CHARLOTTE - MECKLENBURG
PLANNING COMMISSION

INTER - OFFICE COMMUNICATION

SUBJECT: Administrative Approval for Petition No. 1997-34(c) by First Colony Group.

TECHNICAL DATA PLAN FOR PETITION #9734C
 A MIXED-USE COMMUNITY
 AT PROSPERITY TOWN CENTER

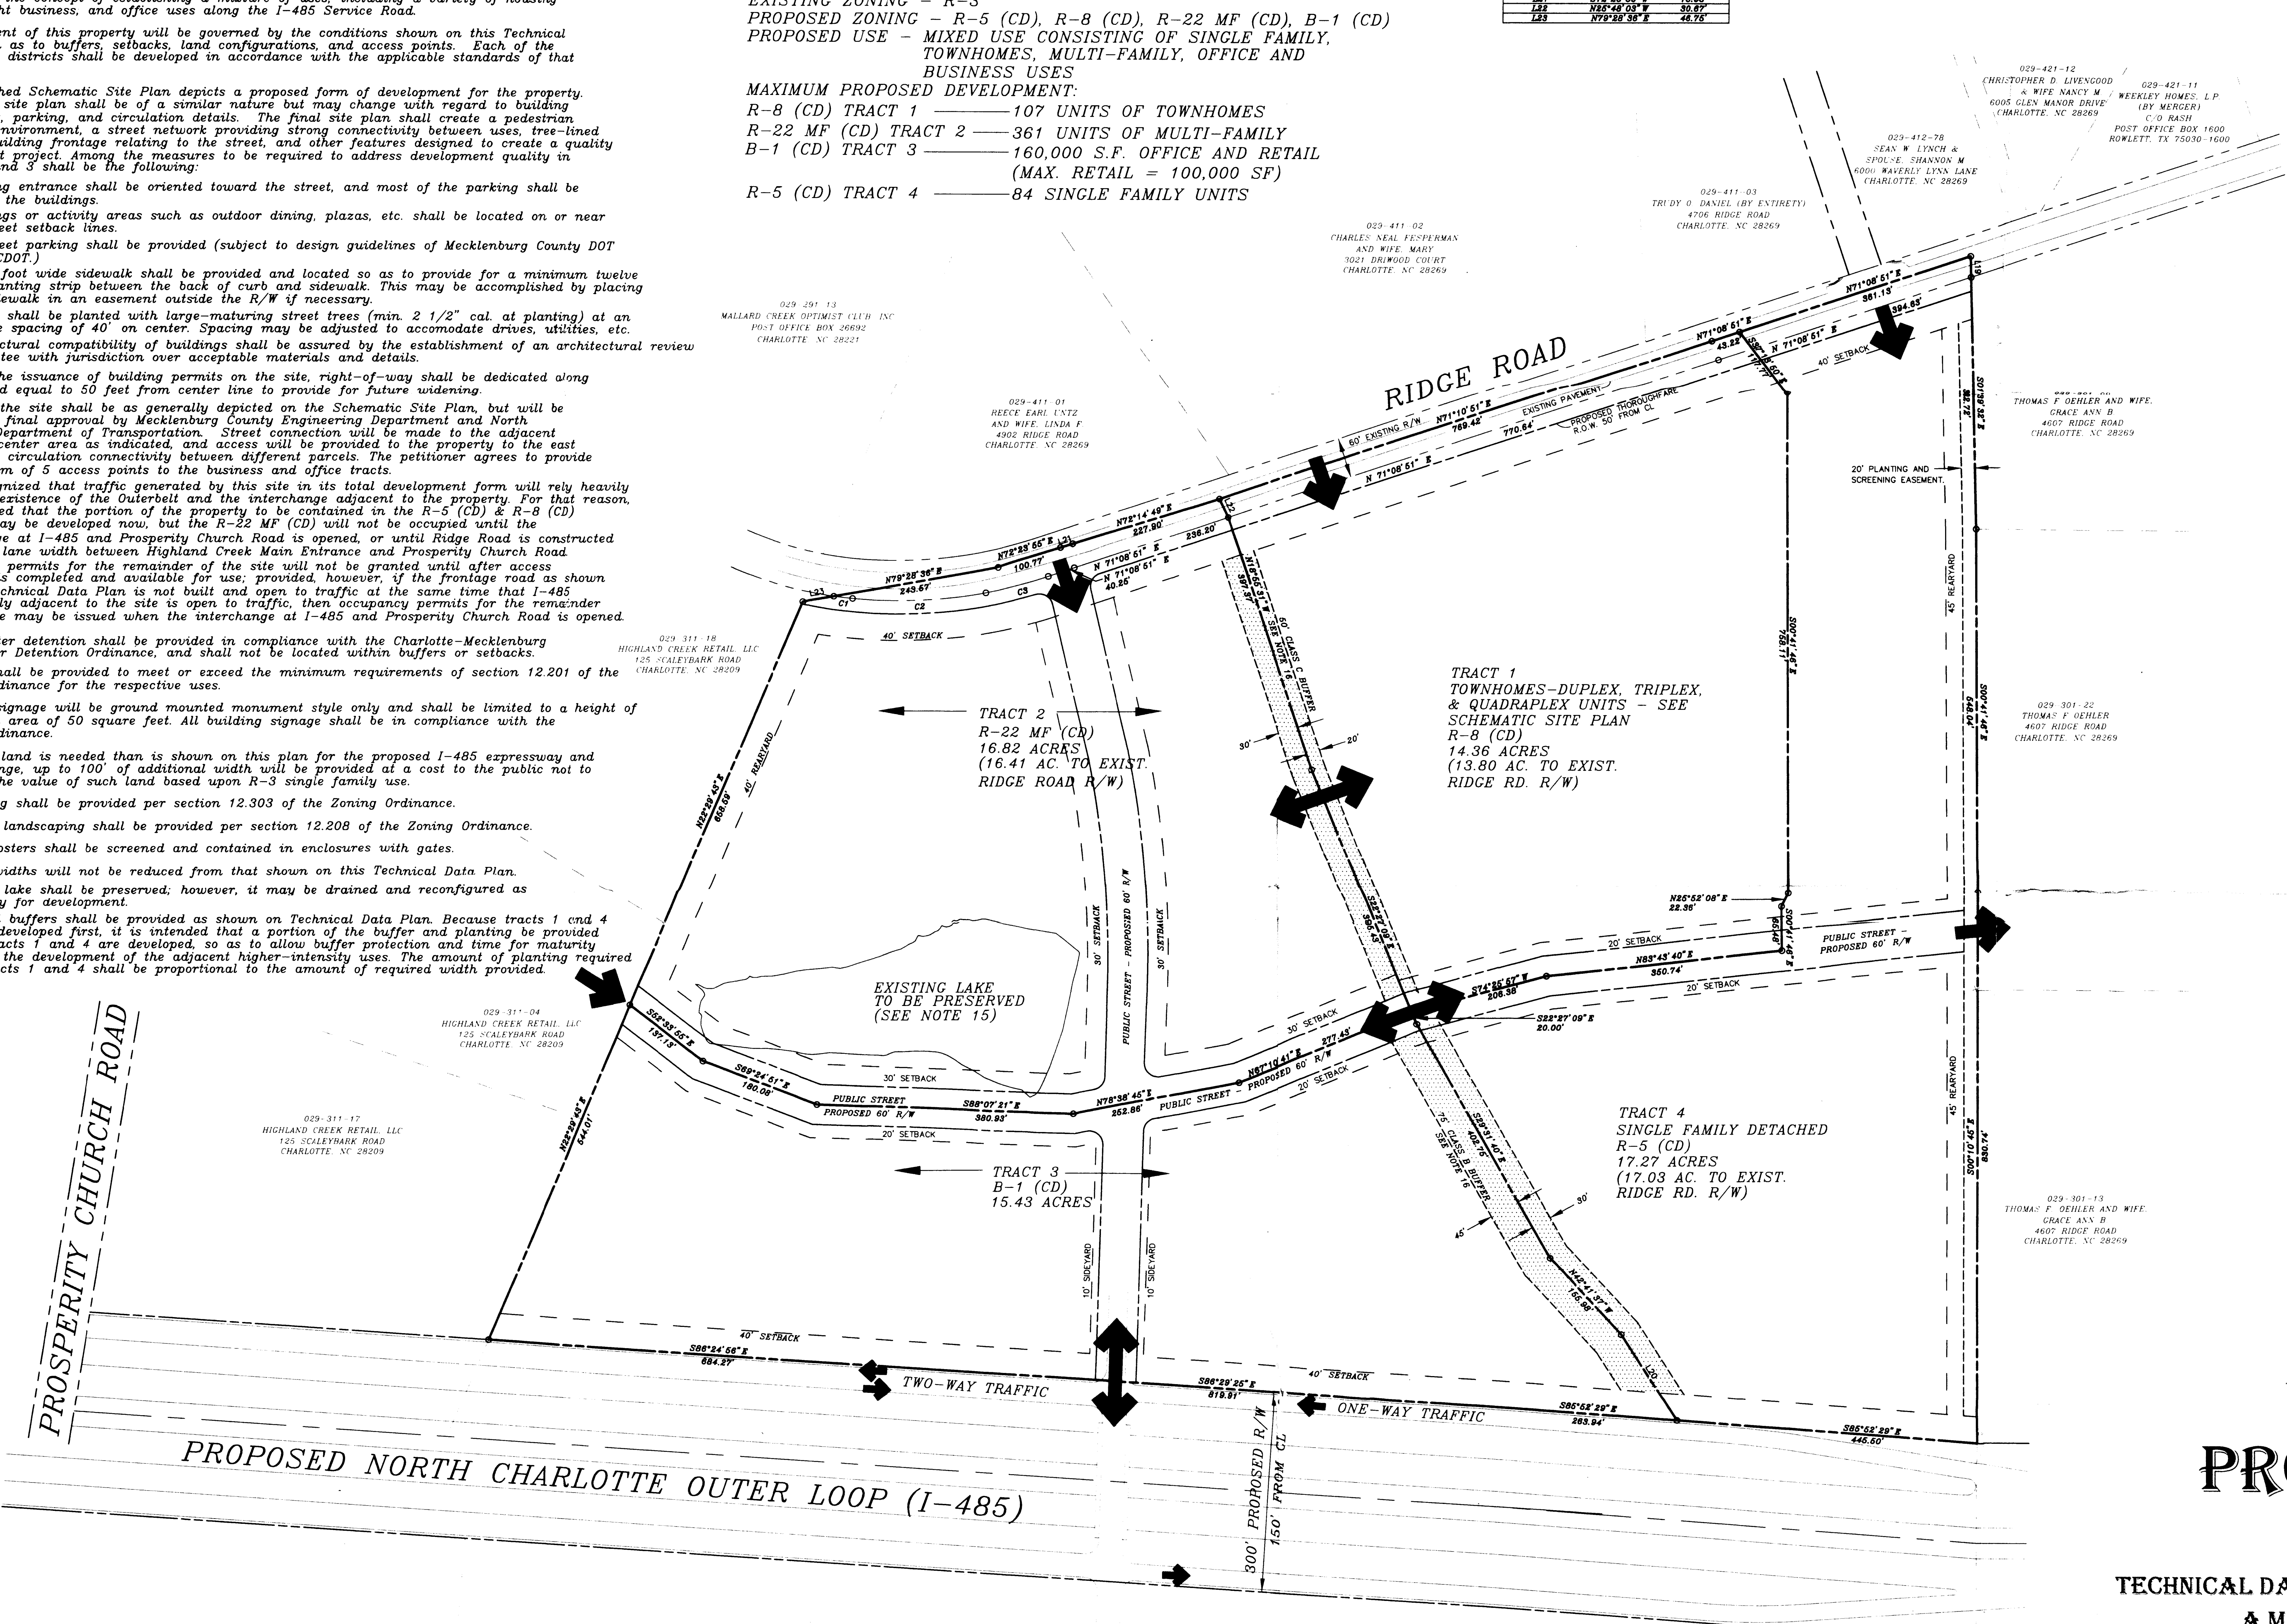
Attached is a revised plan for the above petition. The plan has been revised to shift the access points. Since this change is minor, I am administratively approving this revised plan. Please use this plan when evaluating requests for building permits and certificates of occupancy.
